Our Ref: PAA/108/17/

Pre-Application Advice

Demolition of existing house and erection of replacement house.

Sanderlings Middle Way Kingston Gorse East Preston

Proposed street scene AA

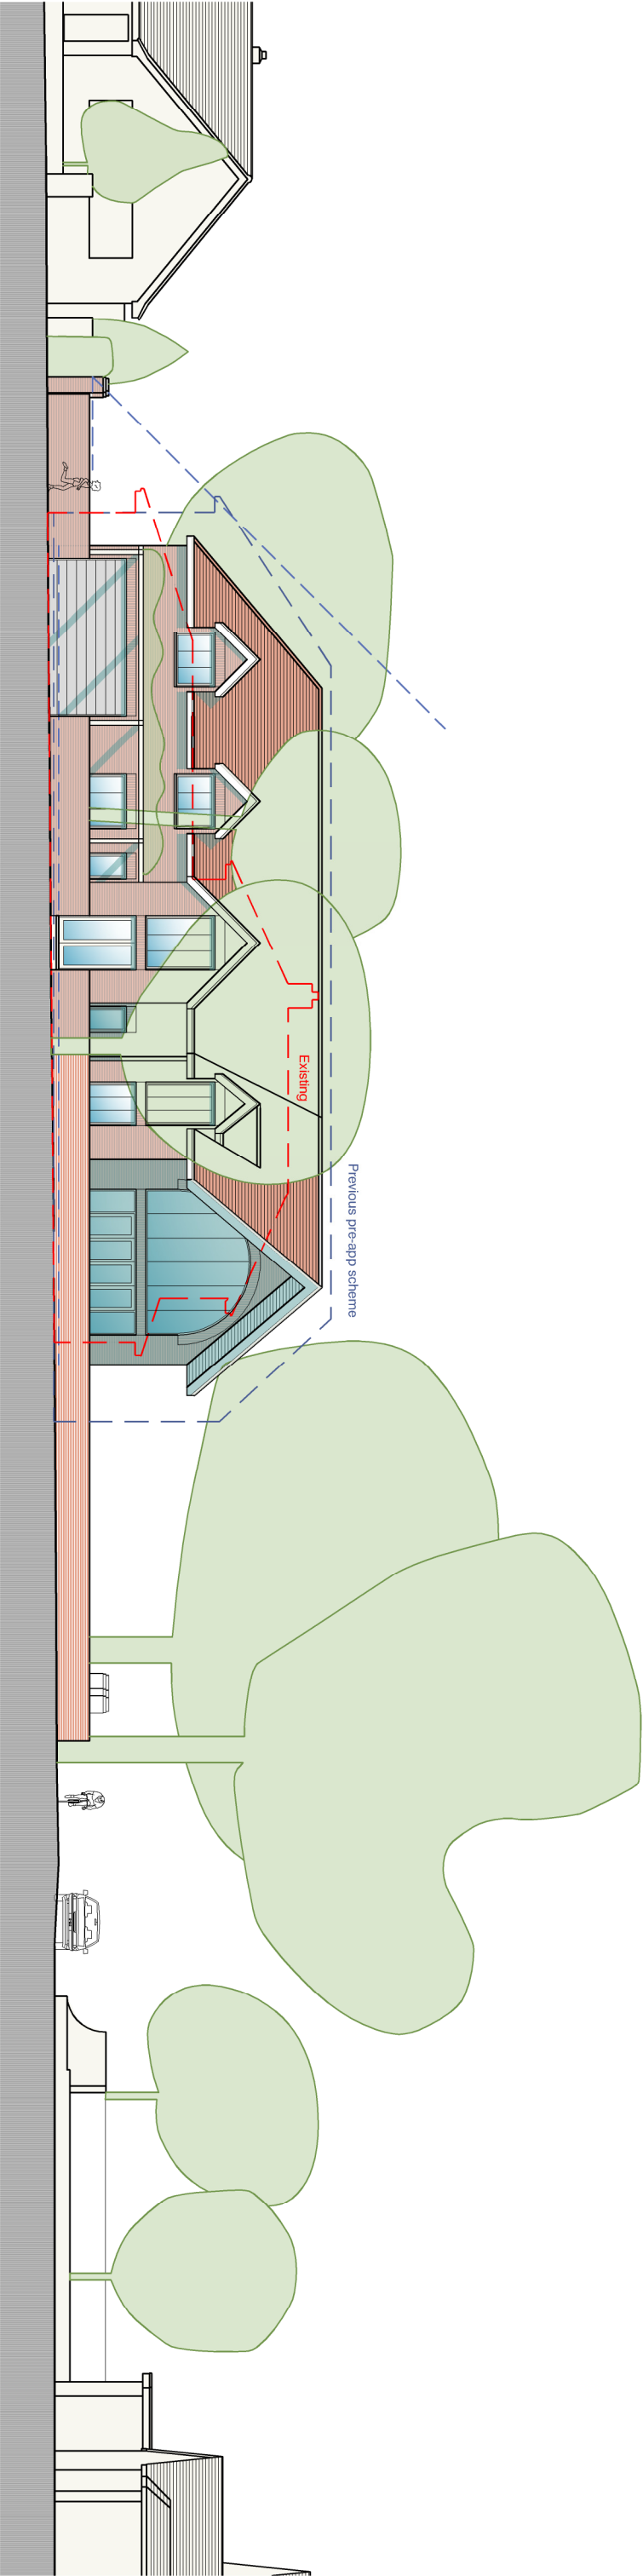
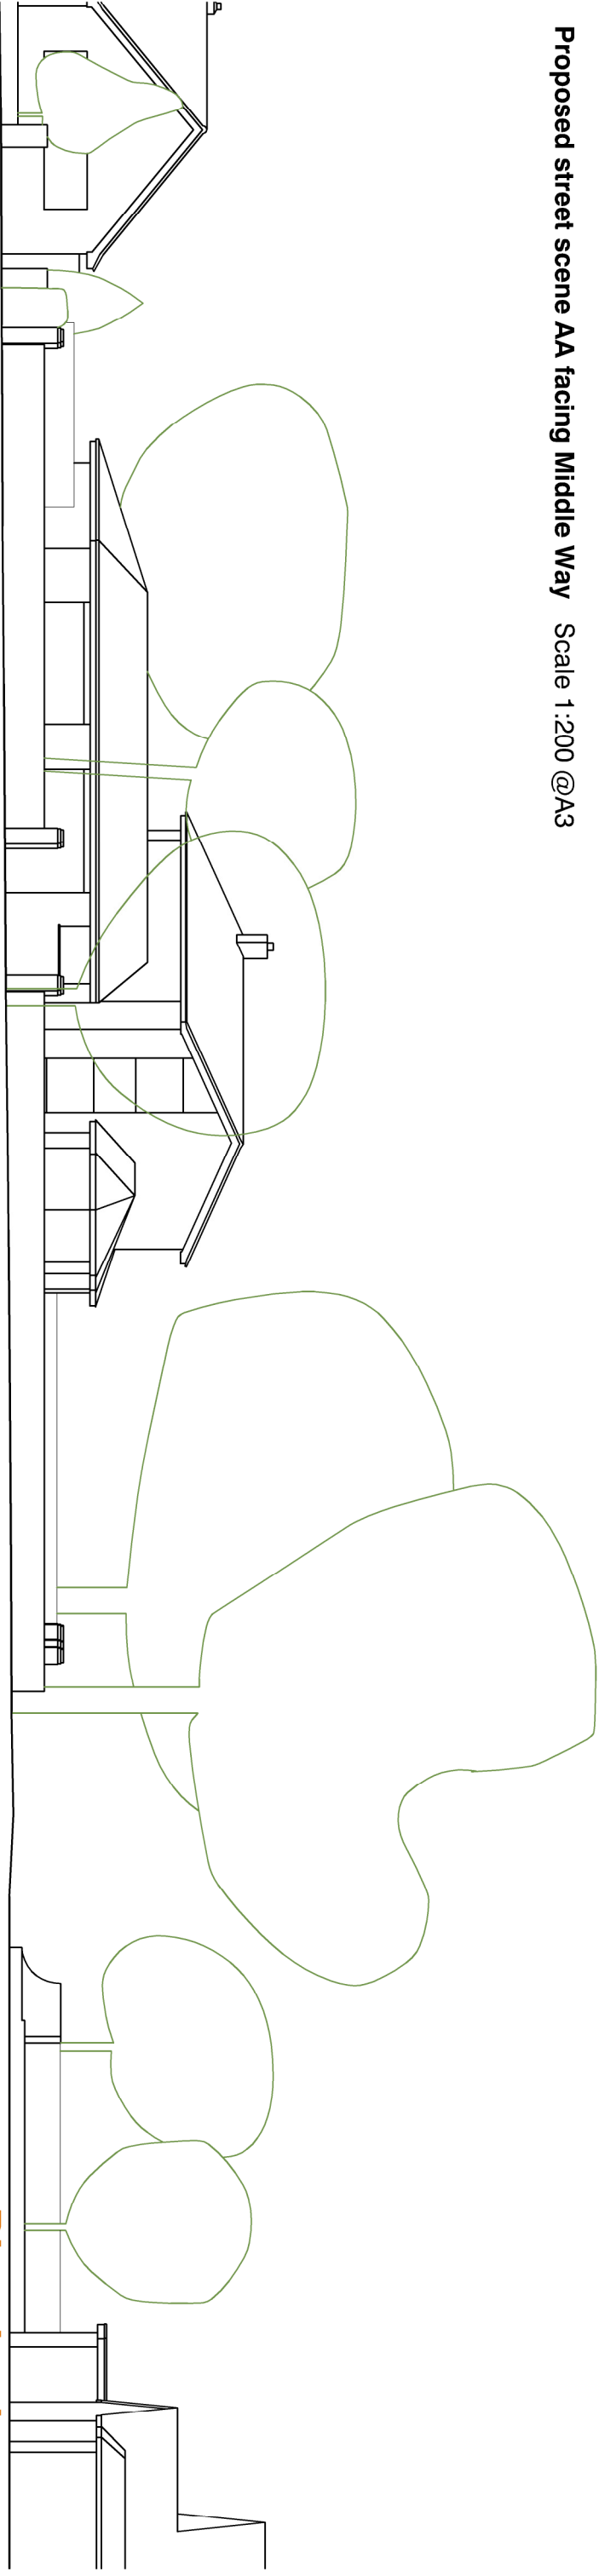
The proposed dwelling by virtue of its considerable footprint in relation to the plot size and two storey height within a prominent location is considered to have a detrimental impact upon the established character of the street scene. The proposed dwelling will extend almost the full width of the plot and will have a frontage of approximately 50m. It is apparent that attempts have been made to maximise the size of the dwelling given the plot size - however, in this instance it is considered that the proposal will constitute over development of the site.

It is acknowledged that the existing dwellinghouse extends forward of the building line on Middle Way and Sea Lane but it must be considered that the existing dwelling features significant single storey portions and as such has a far lesser impact on the character of the locality. The proposed replacement dwelling also incorporates a two storey projection to the north-west which will extend between 6.68m and 10.83m forward of the existing two storey dwellinghouse. Therefore, the proposed dwellinghouse is considered to appear incongruous and is deemed to have an unacceptable impact upon the character of the locality.

It is considered that efforts should be made to the reduce the mass, bulk and scale of the proposed development and seek to better reflect the scale of neighbouring dwellings. Especially to the east of the application site.

- Reduced, in footprint and height to better reflect the scale of neighbouring development.
- Reduce the size of the two storey forward projection to minimise the impact of the proposed development upon the spatial pattern and character of the street scene.
- Seek to reduce the impact of the proposed development upon the residential amenity of neighbouring properties.

Block & site location plan

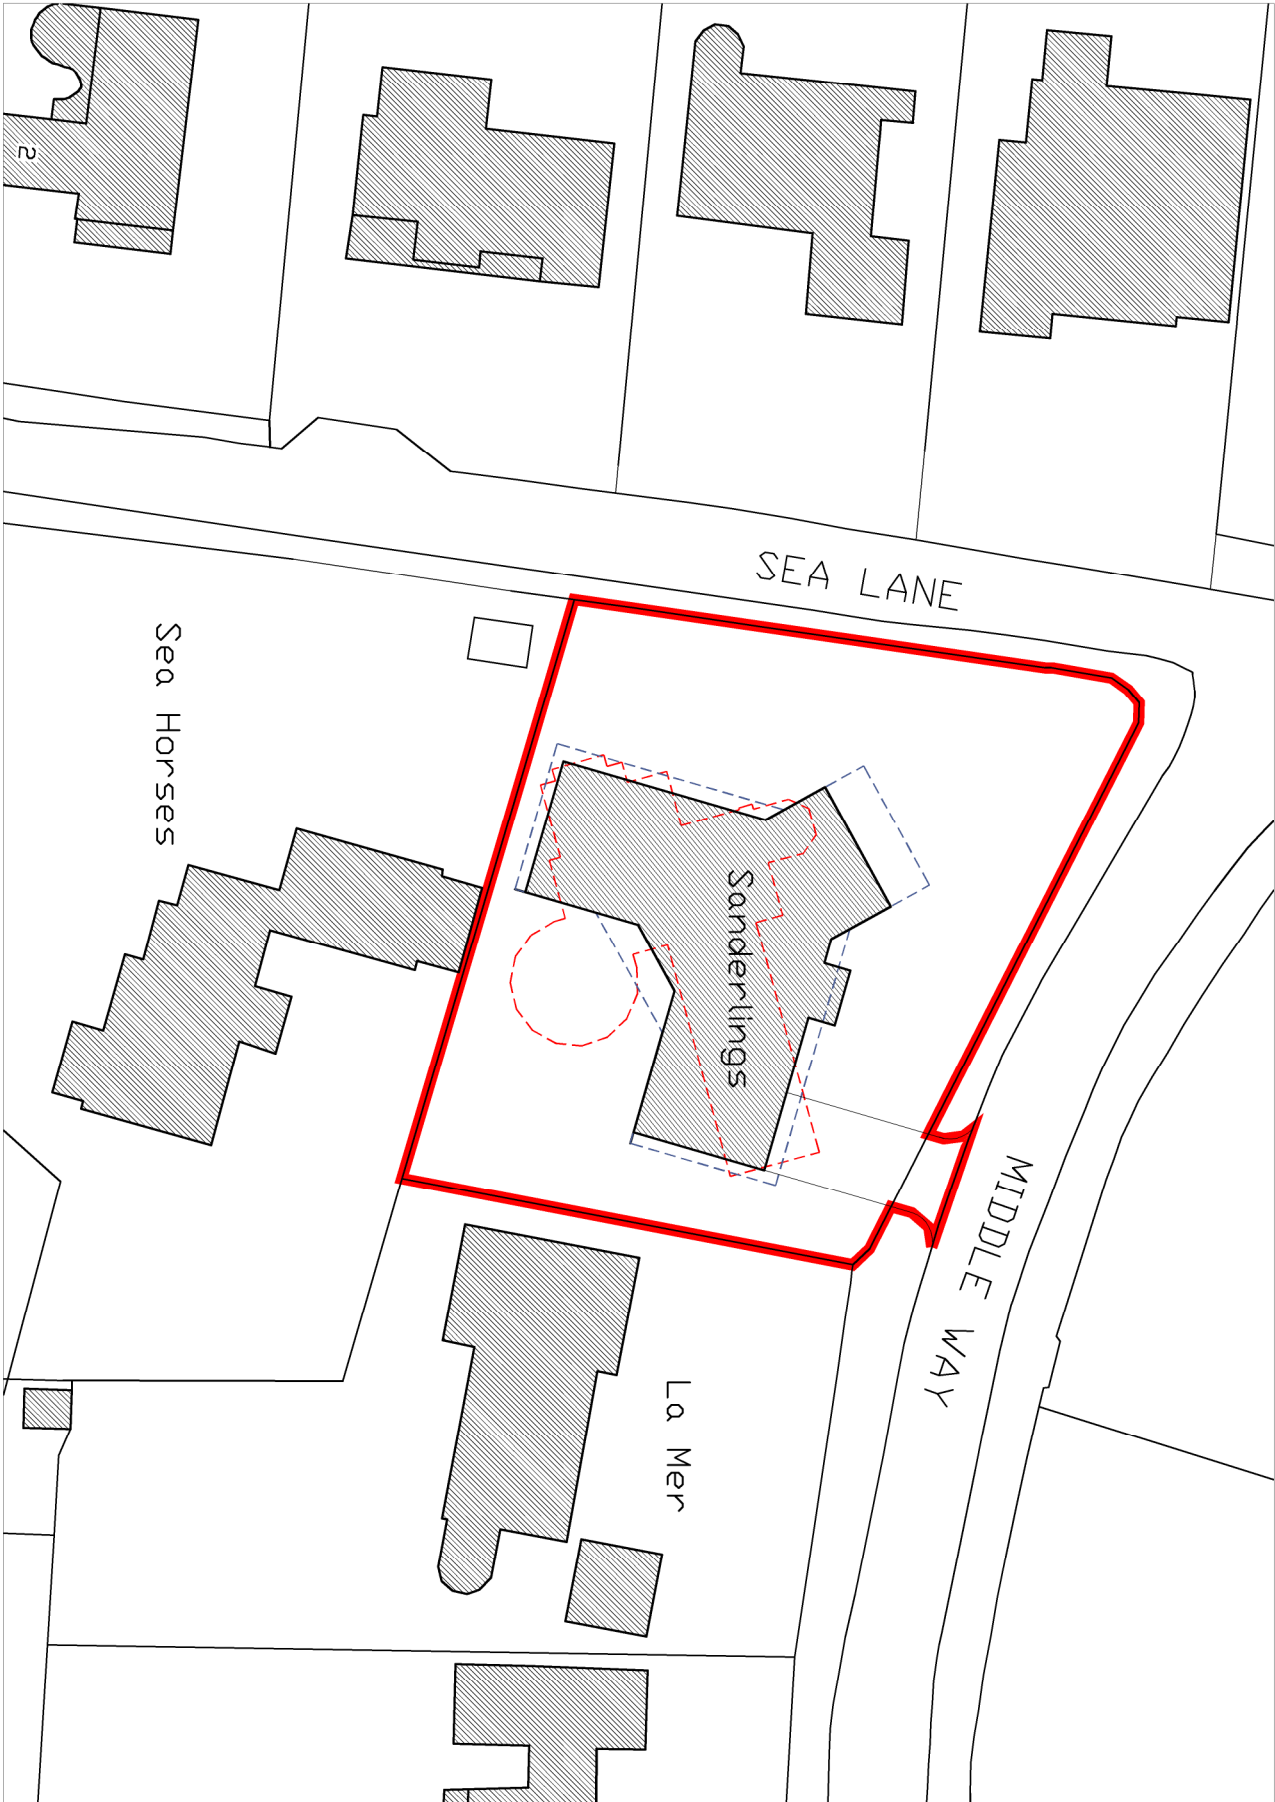
The proposed replacement dwelling will be situated approximately 5.3m from the eastern boundary of the site and 1.8m from the southern boundary. It is considered that the proposed dwelling will not give rise to any unacceptably adverse overbearing or overshadowing impacts upon neighbouring properties. The application has provided site lines for neighbouring dwellings which suggest a marginal failure of the 45 degree rule and as such it is not considered that the proposal will result in unacceptable harm. It must also be considered that the proposed dwelling will be off set from neighbours to the east and south.

The proposal as submitted shows that the rear elevations at direct angles will be situated 16m (from the southern boundary) and 19m from the eastern boundary. However, the proposal will also feature a first floor balcony to the rear which by virtue of its orientation will be situated at its closest point 9m from the southern boundary and 13m from the eastern boundary of the site.

The dwelling to the east of the site 'La Mer' is a chalet bungalow and features 3 no. roof lights in the western elevation - it has not been possible to ascertain what rooms these roof lights are associated with but given the close proximity of the balcony to this boundary there is the potential for adverse overlooking. Especially when the size of the balcony and the extent of the proposed glazing is considered.
